EPC STORMWATER REVIEW COMMENTS  
IN ORANGE BOXES WITH BLACK TEXT

LOT 1 WOODMEN HILLS  
FILING NO 7H  
PRELIMINARY GRADING PLAN

PCD FILE NO. PPR2049

**LOT 1 WOODMEN HILLS FILING NO 7H GRADING & EROSION CONTROL PLAN**

DESIGNED BY:	DLM	DRAWN BY:	DBM
SCALE:	1" = 20'	DATE:	12/21/20
JOB NUMBER	20-256	SHEET	2 OF 3

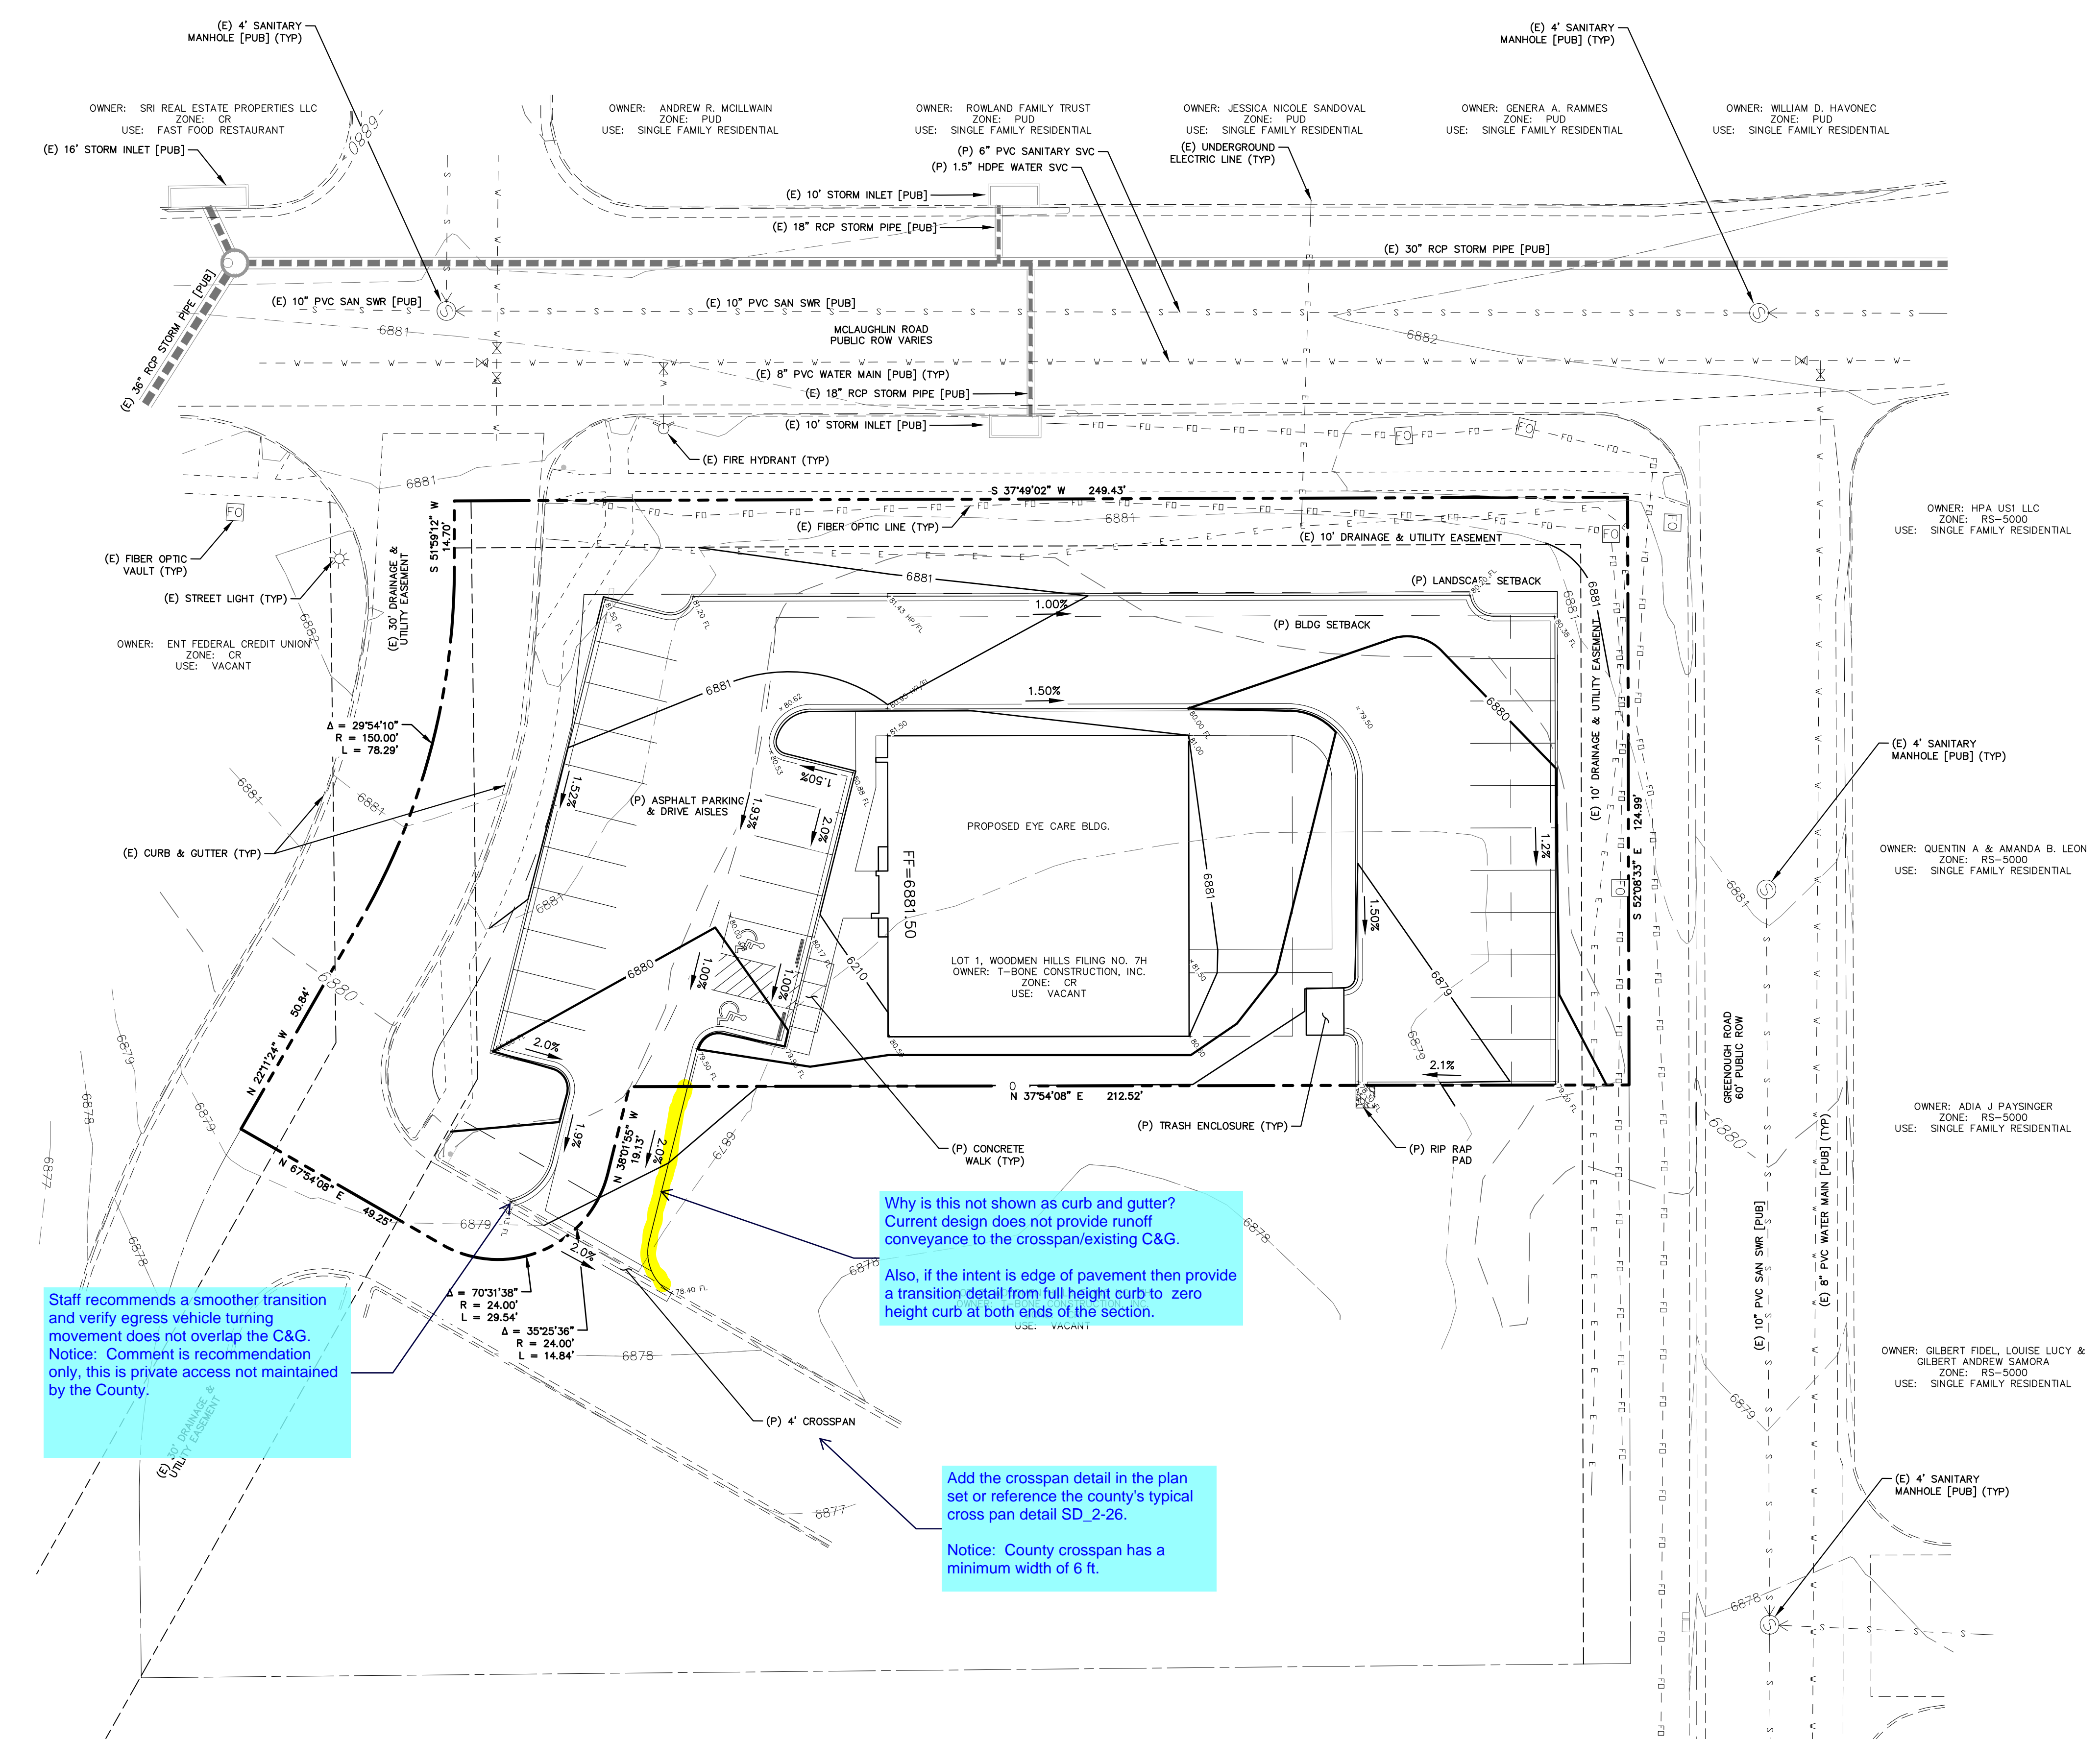
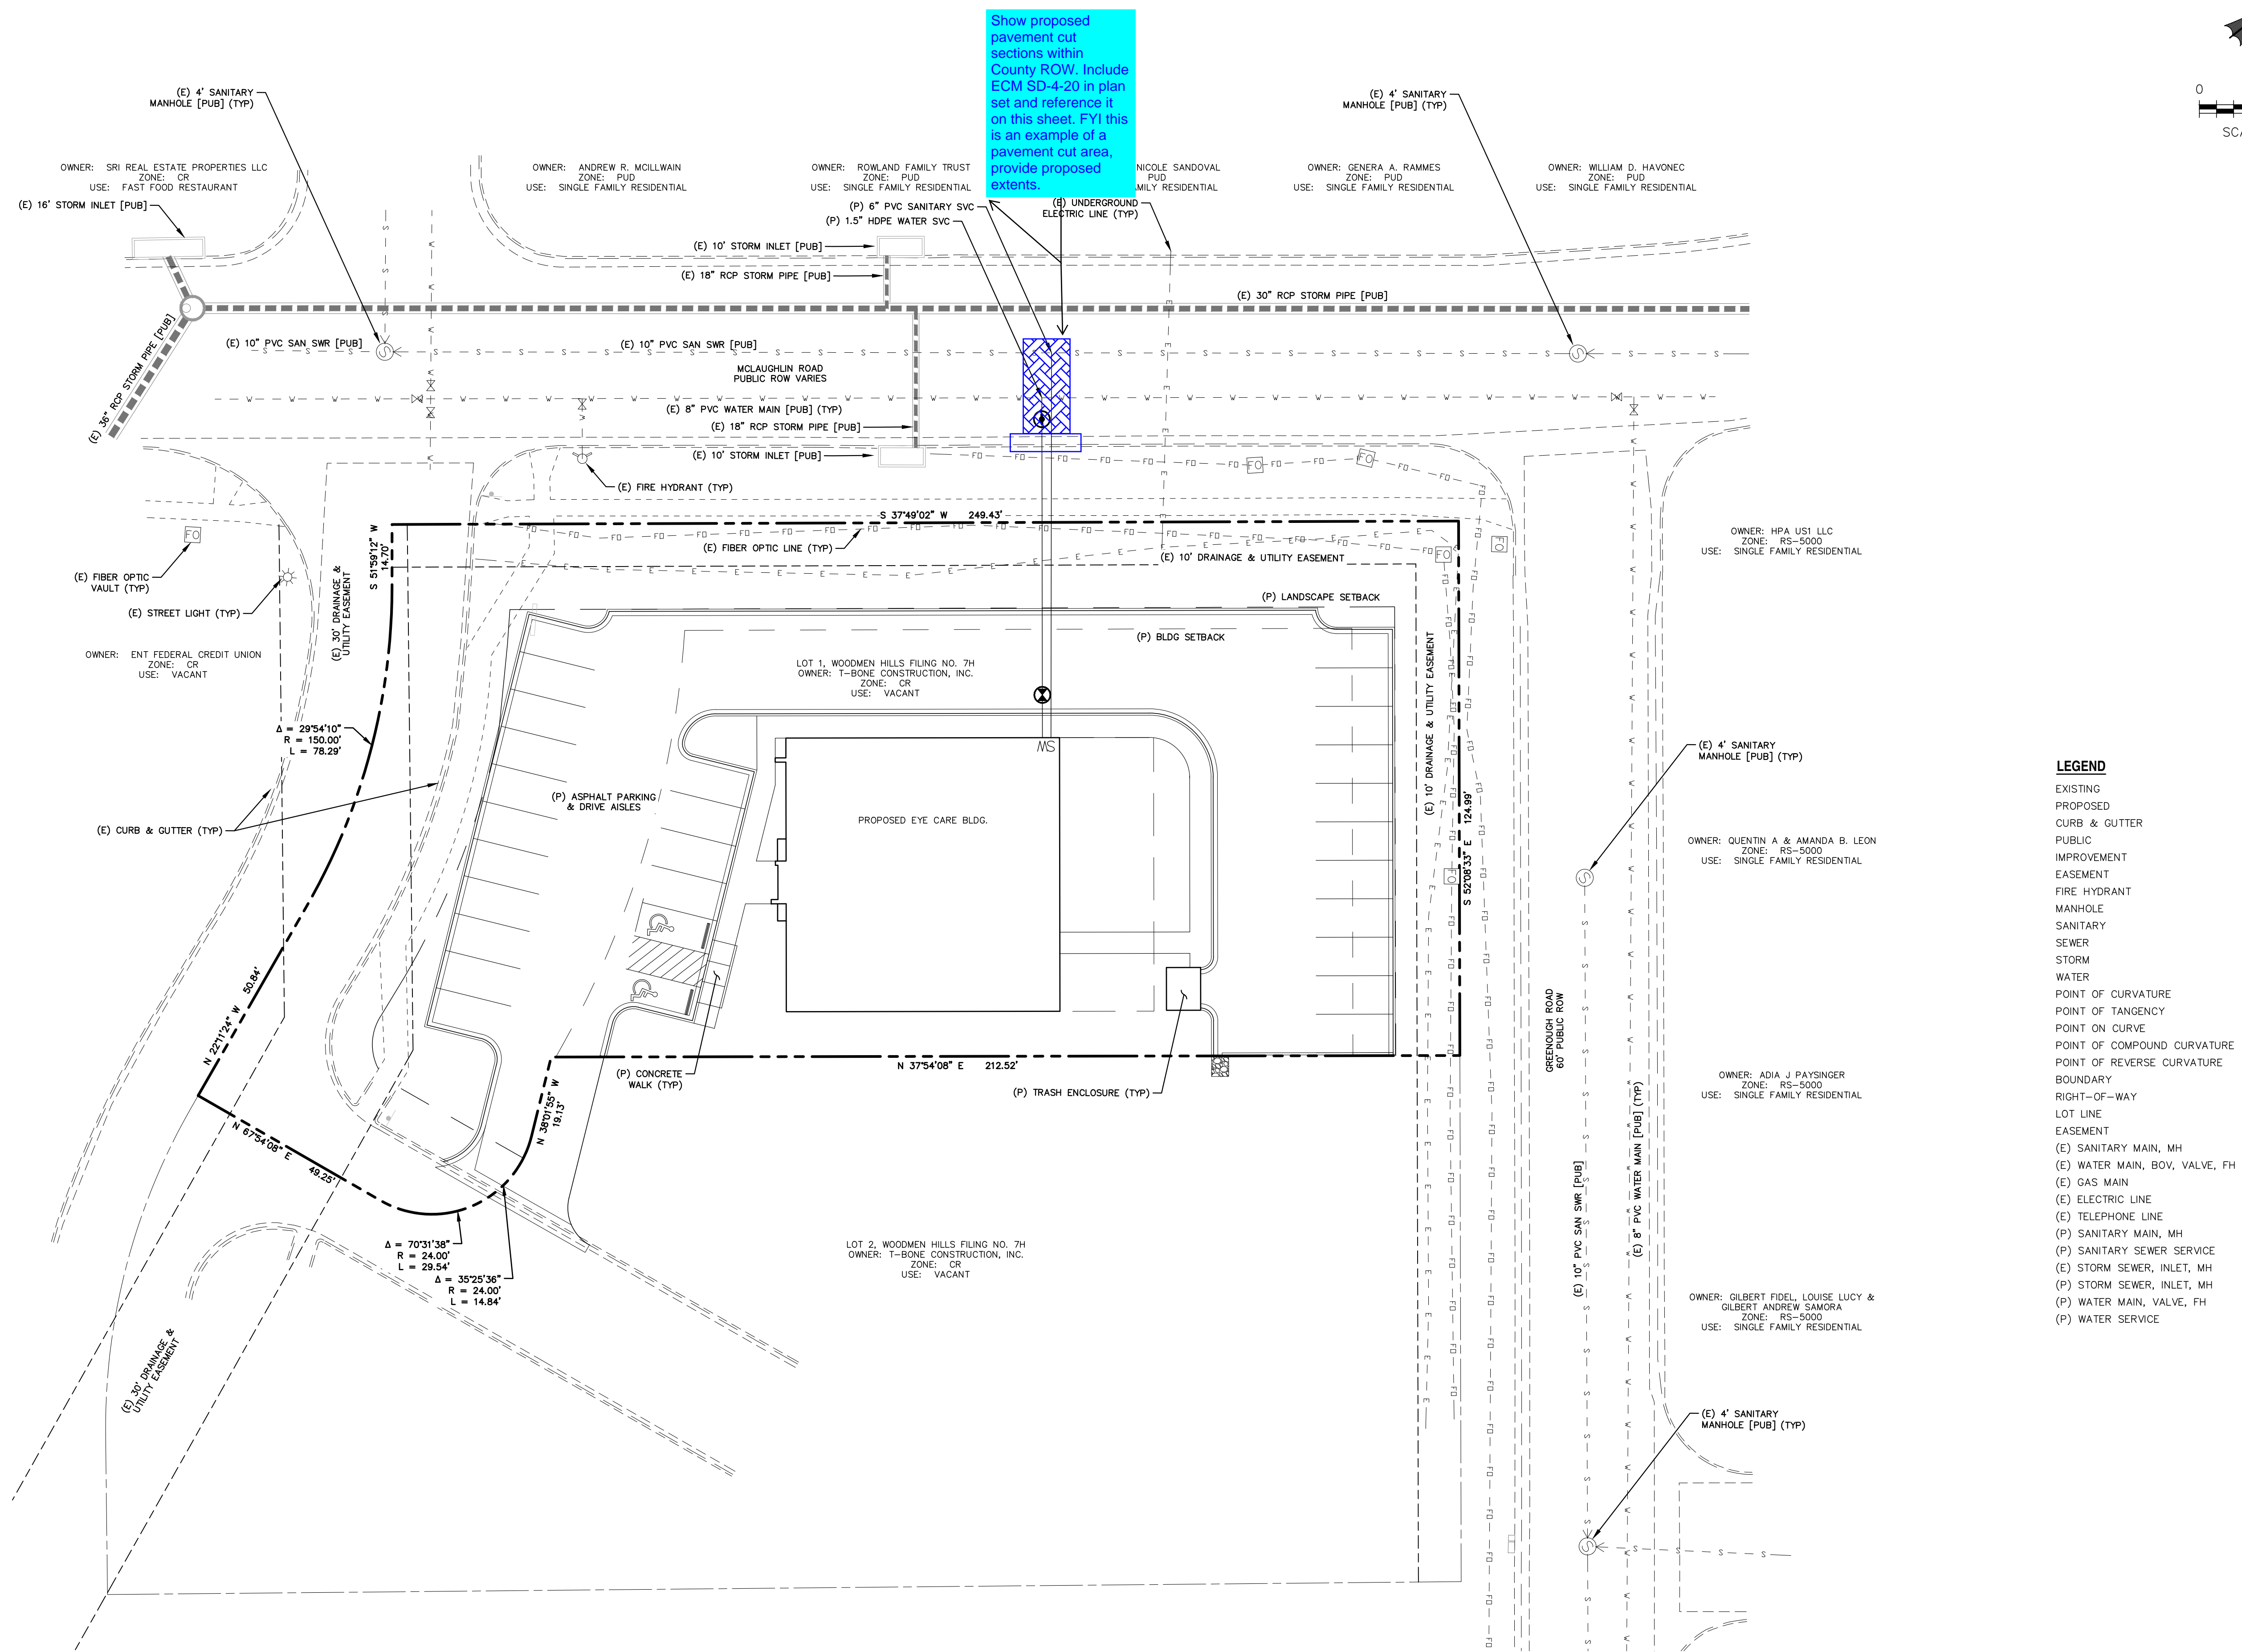
Show location of storm sewer for FDR (pg 29 of 191) from SF98030 and/or per County GIS. Approximate location shown here. Label as (E) 60" RCP (typical comment for all 3 plan drawings in this file)

GEC Checklist Item BB - Show a vicinity map large enough to include Pond #4. Label the pond and reference project # SF98030

No drainage swale shown on plans. If not anticipated, remove from legend and remove detail on next sheet.

Is there an agreement in place with the adjacent property owner that they will provide drainage for the stormwater that outfalls here? If so, add a note here that clarifies the situation - reference agreement, describe what plan for the runoff is across this neighbor's lot.

Provide type, size, and depth of riprap.

See comment on page 4 of 14 of FDR.

Theres an inlet somewhere down here that can be seen on Google Street. It appears that most of the stormwater runoff from the site will be directed to this inlet.

Please show this inlet on this drawing with IP.

And include calcs in the drainage report that show that the inlet has enough capacity for the flow, since this inlet is "By Others" according to the FDR from SF98030. Therefore, no calcs were provided with SF98030 that can be referenced (similar to how Pond #4 has calcs with SF98030, so you don't need to show these pond calcs again). If these inlet calcs can be found in another project besides SF98030, it's ok to reference that project, as long as they included the development of this lot for PPR2049 in their calcs. Feel free to call me to discuss.

If the same as the limits of Construction, change to "construction boundary/limits of disturbance" or add "limits of construction" to the legend and figure (per GEC Checklist Items H and M)
